**WELWYN HATFIELD BOROUGH COUNCIL
EXECUTIVE DIRECTOR - PLANNING, PUBLIC PROTECTION AND GOVERNANCE**

Application No: 6/2021/2212/EM
Location: 54 Bridge Road Welwyn Garden City AL8 6UR
Proposal: Construction of 2x two-storey detached houses and associated parking and access on the land to the rear of 52 & 54 Bridge Road.
Officer: Mr James Homer

Recommendation: Refused

Project: RO Bridge Road, 52&54 AL8 6UR
Client: Mr A. Burton
Title: Proposed Site Plan - No.54
Scale @ A1: 1 : 100
Drawing No: 1644.EM2.05

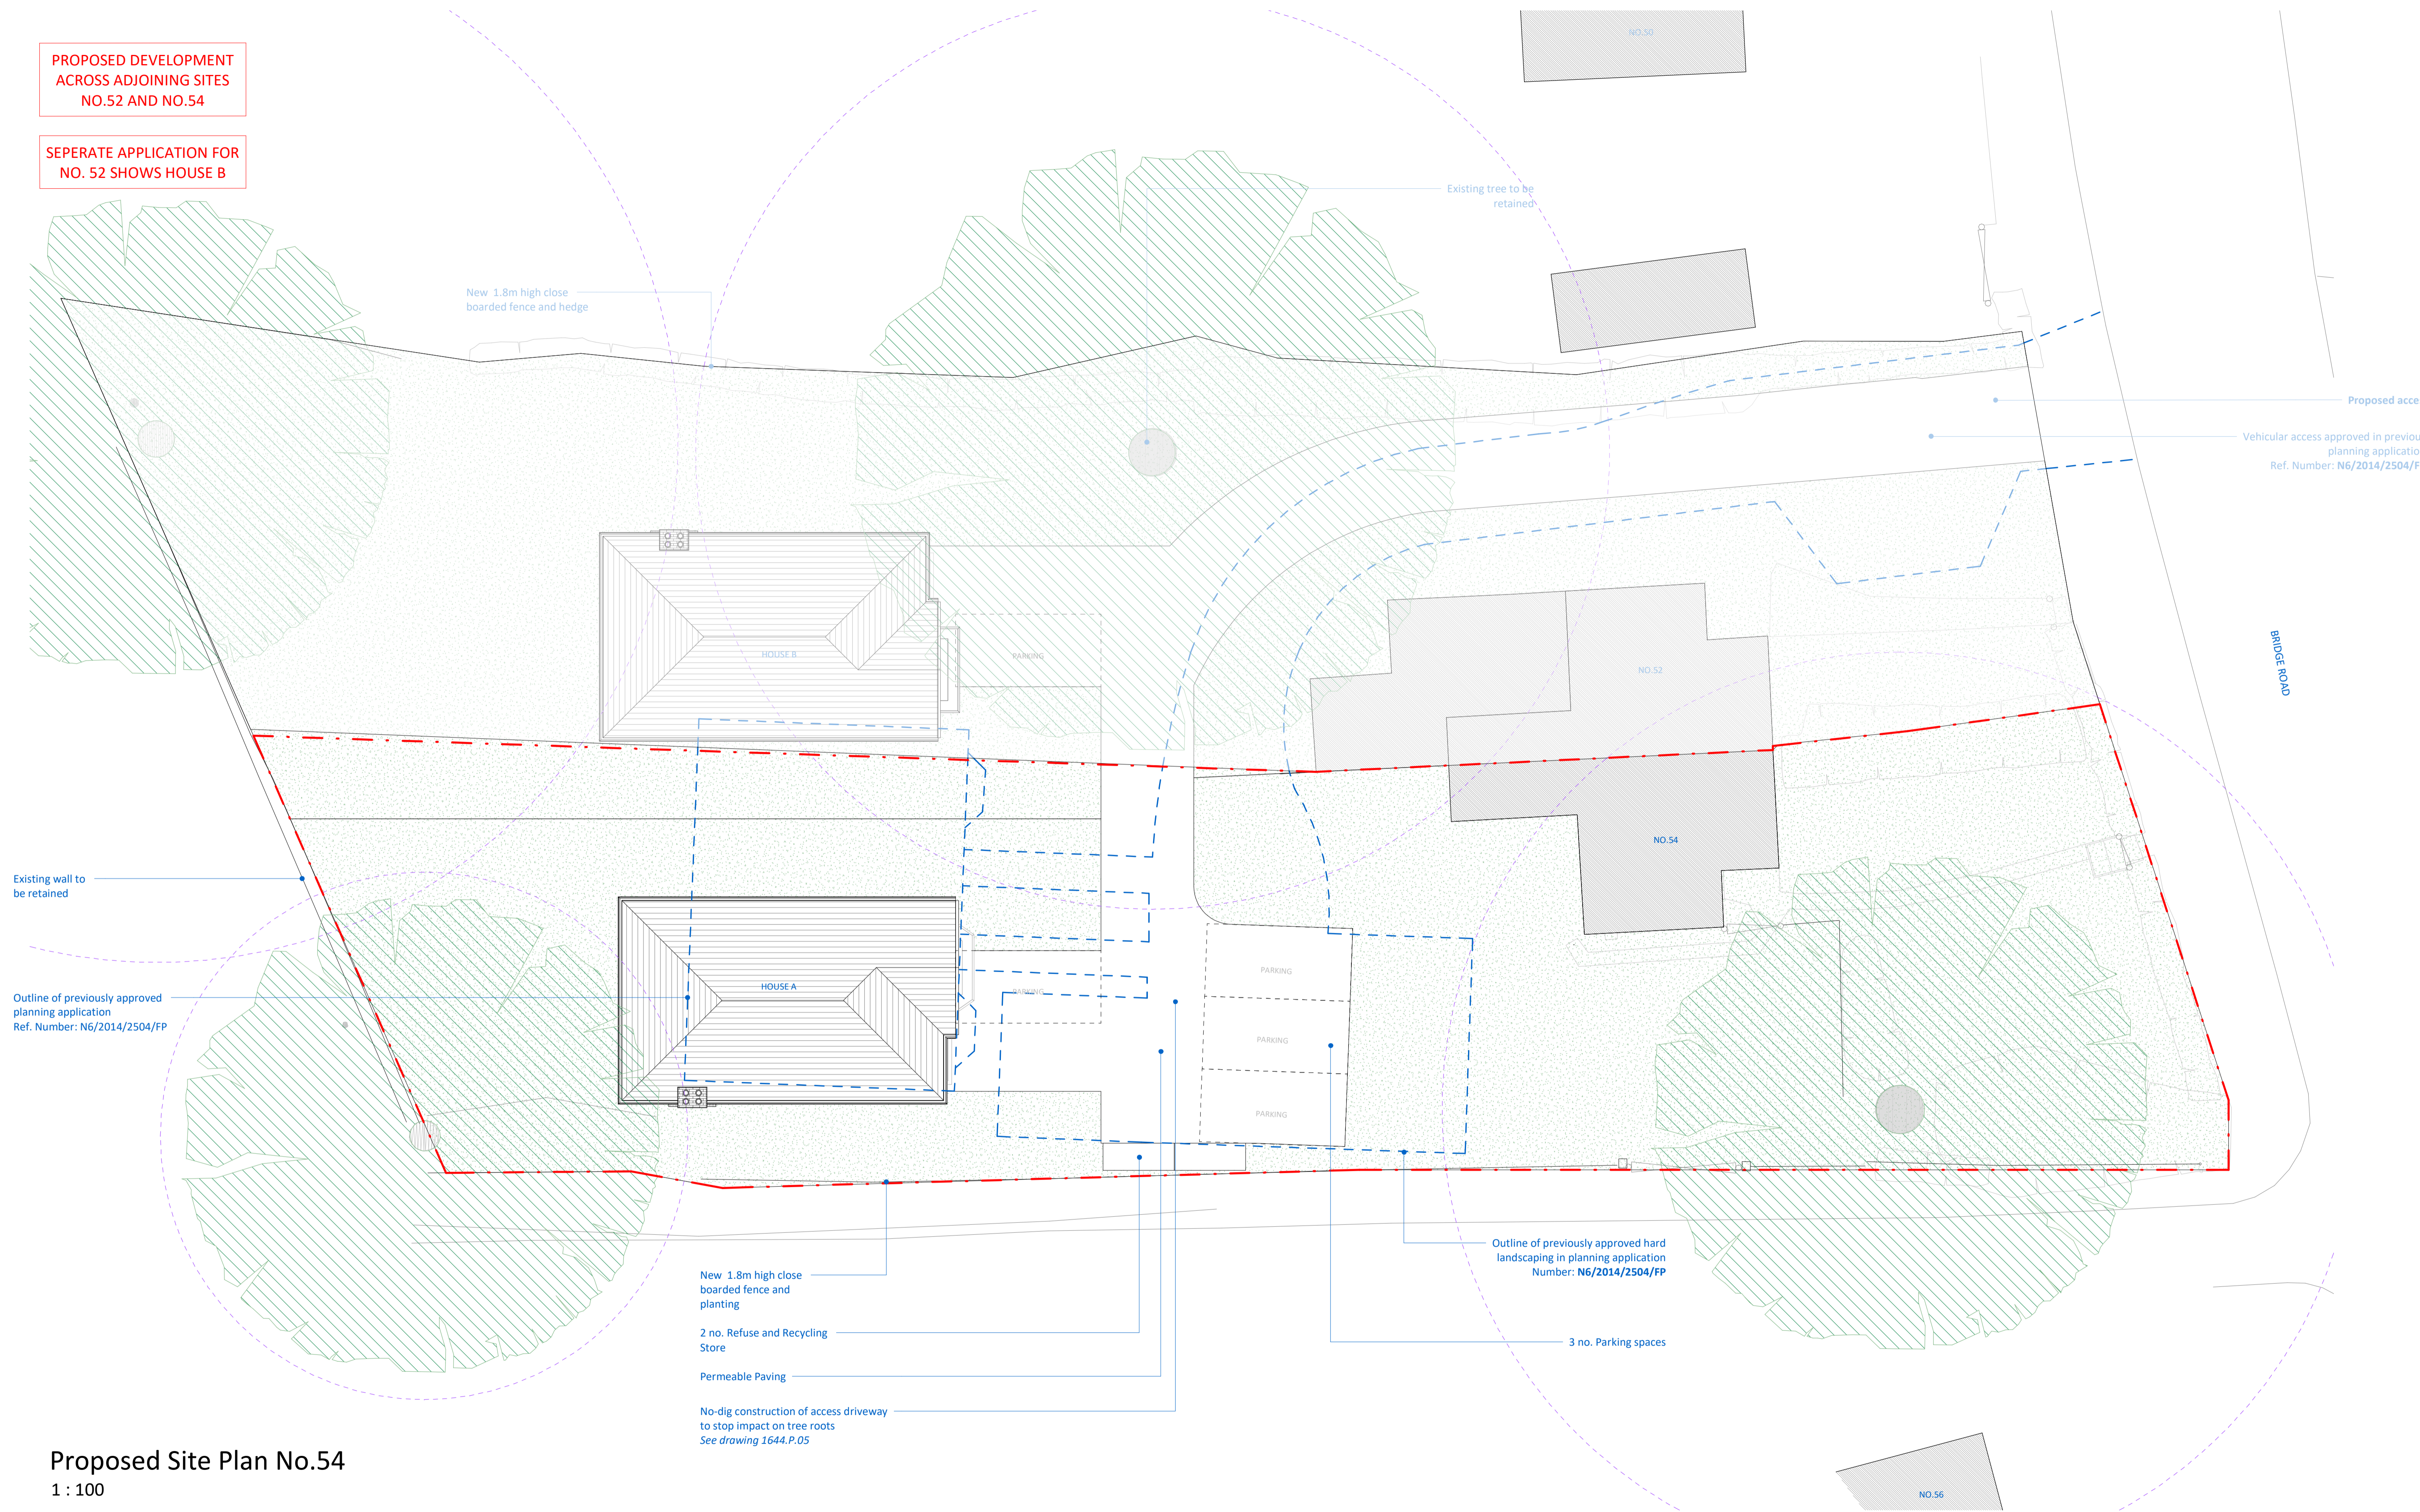
1. Despite the sympathetic design, the proposed new dwelling to the rear of no.54 would not respect the visual appearance of the area in terms of its siting and would result in a visually over prominent and discordant addition to the rear of the existing property that would result in harm to the character of the site and wider area of Bridge Road. This is exacerbated by the proposal for a similar dwelling within the rear garden of 52 Bridge Road.

In addition, the proposal would result in the loss of at least six trees within the rear garden of the existing site that is considered harmful to the verdant setting of the property and character of the wider area.

As a result, the application fails to comply with Policy EM2 and Policy EM3 of the Estate Management Scheme.

Project: RO Bridge Road, 52&54 AL8 6UR
Client: Mr A. Burton
Title: Proposed Plans and Elevations
Scale @ A1: 1 : 100
Drawing No: 1644.EM2.06

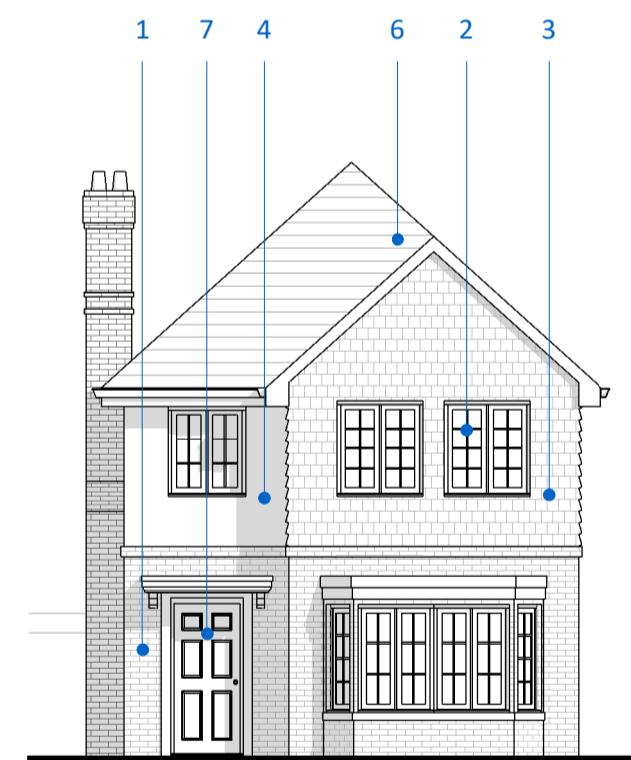
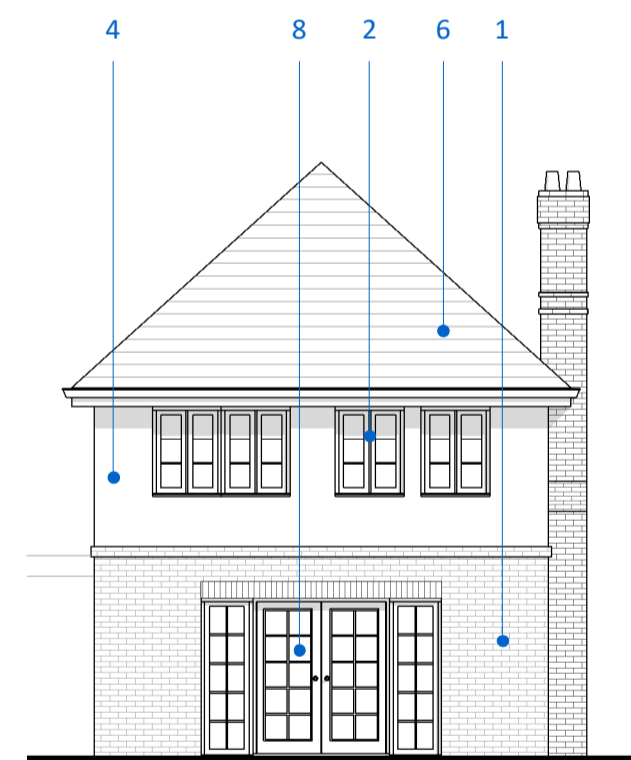
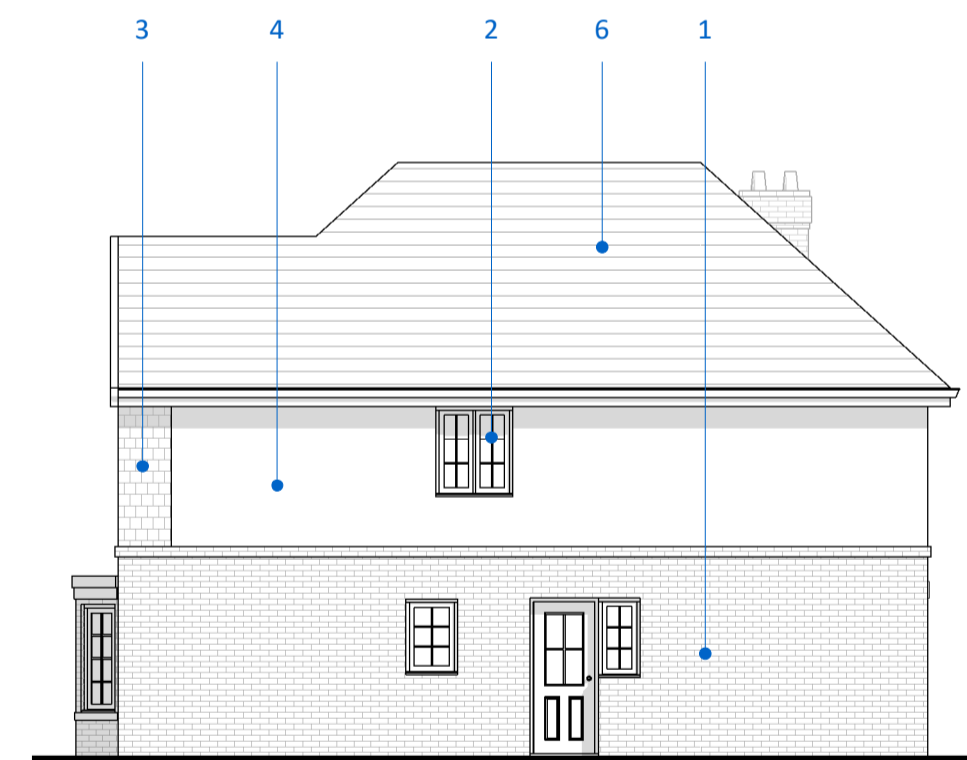
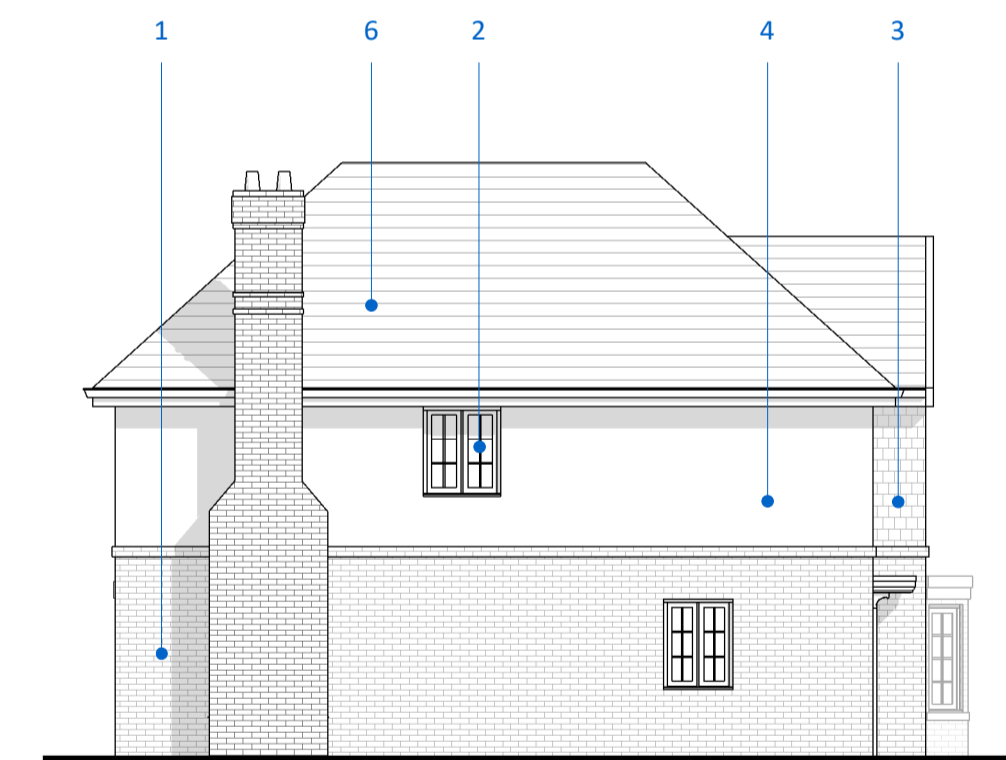
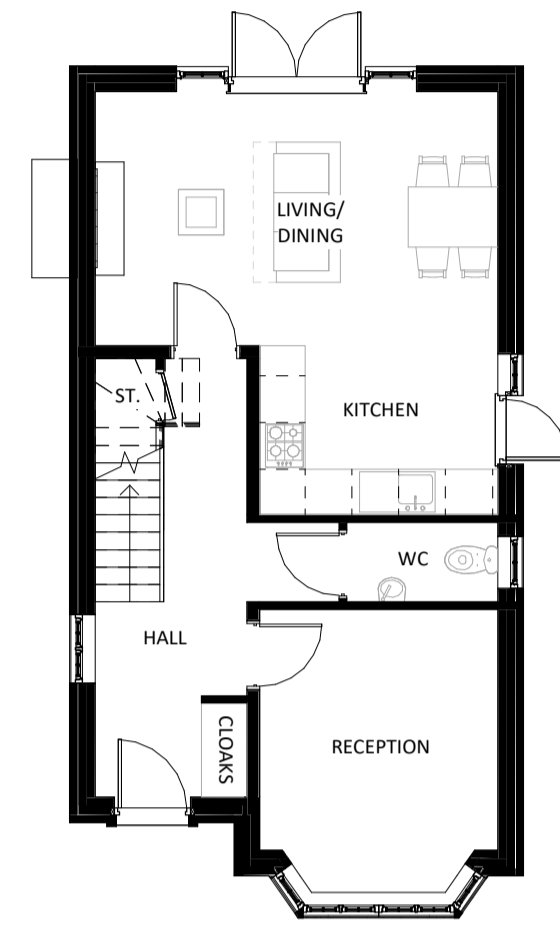
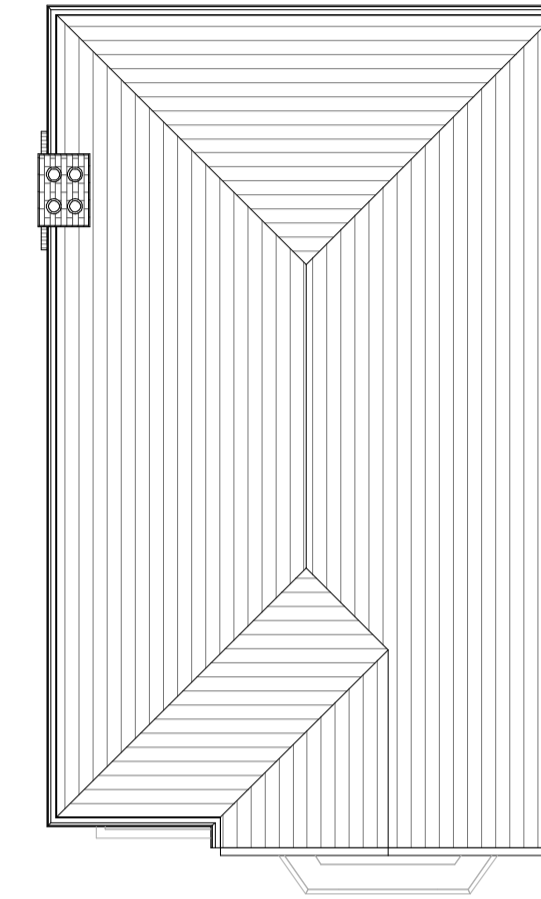
<p>The proposed house to be erected within the current rear garden of no.54 would feature a clay tiled hipped roof with a front gable projection with brickwork finish at ground floor and timber cladding finish at first floor. Conservation casement windows are proposed for the front and side elevations and first floor at the rear. The application proposes a timber front door and conservation style French doors with side lights at the rear.</p> <p>Despite the sympathetic design, the proposed building would appear out of place within the area as there are no properties set back behind the existing properties fronting Bridge Road. As a result, the proposed dwelling, together with the existing dwelling, would appear excessive, resulting in the site appearing overdeveloped and out of keeping with the immediate character of the area.</p> <p>Furthermore, gardens are considered an important component of the Welwyn Garden City and create important open space between homes and amenity areas. The sub-division of this plot would result in a significant loss of garden to the rear of 54 Bridge Road and the erection of a large house to the rear would upset the balance of the open space between the houses along Bridge Road and the edge of the woodland to the rear of the site. Ultimately, the proposal would result in a more cramped site that is out of keeping with the area resulting in a detrimental impact on the spacious character and appearance of the locality as a whole.</p> <p>Despite the sympathetic design, the proposed new dwelling to the rear of no.54 would not respect the visual appearance of the area in terms of its siting and scale and would result in visually over prominent and discordant addition. This is exacerbated by the proposal for a similar dwelling within the rear garden of 52 Bridge Road.</p>
